RFI

RFI #: 9
 Date: 12/14/2011
 Job: EB-02 Keller Springs Lofts
 Phone: 877-777-5115

Subject: MC 13A difference on layouts

**E-3.1**

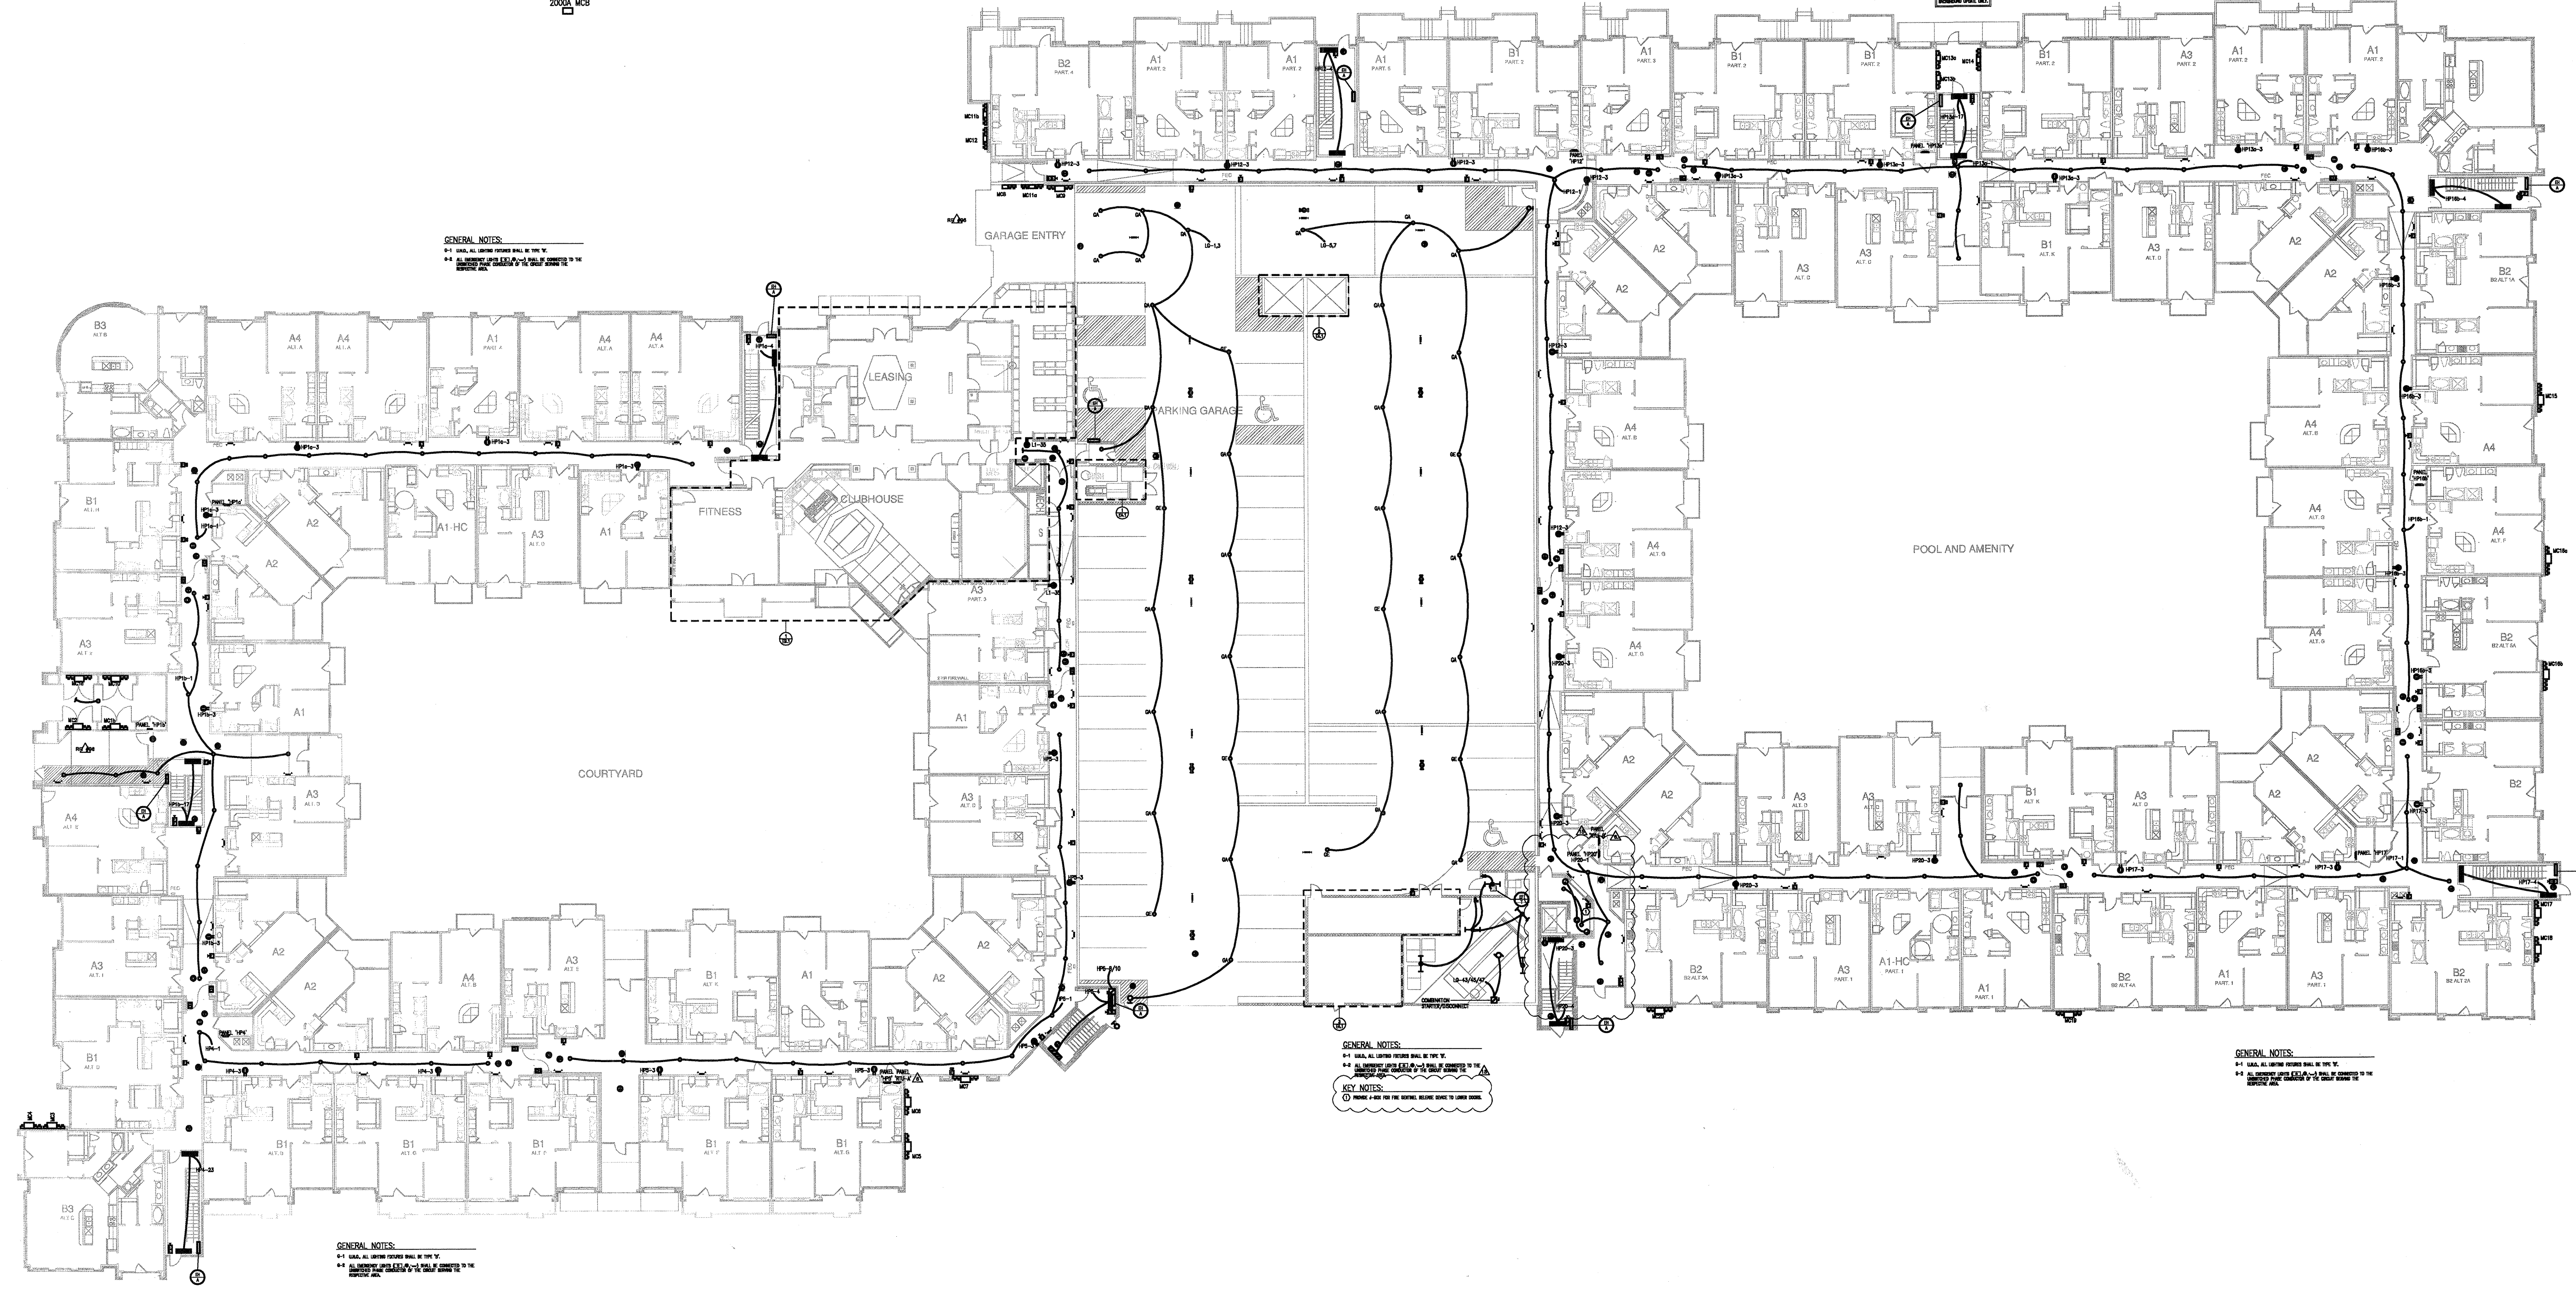
Request: Date Required: 12/21/2011
 MC 13A is not shown on Arch sheet 3.1E, the wall layout is different on the two sheets 3.1E and E3.1E please give direction also should elevation at MC 13A location be 639.1 as indicated on S2.15 Arch sheet 3.1E shows 6" drop should that be 2' 6" drop?

I spoke to JandS and verified we do infact have enough wall space for the required meters shown on the electrical drawings. The foundation plan shows a 2'-6" drop which is correct. The architectural drawing are being revised and will be issues in a few days.
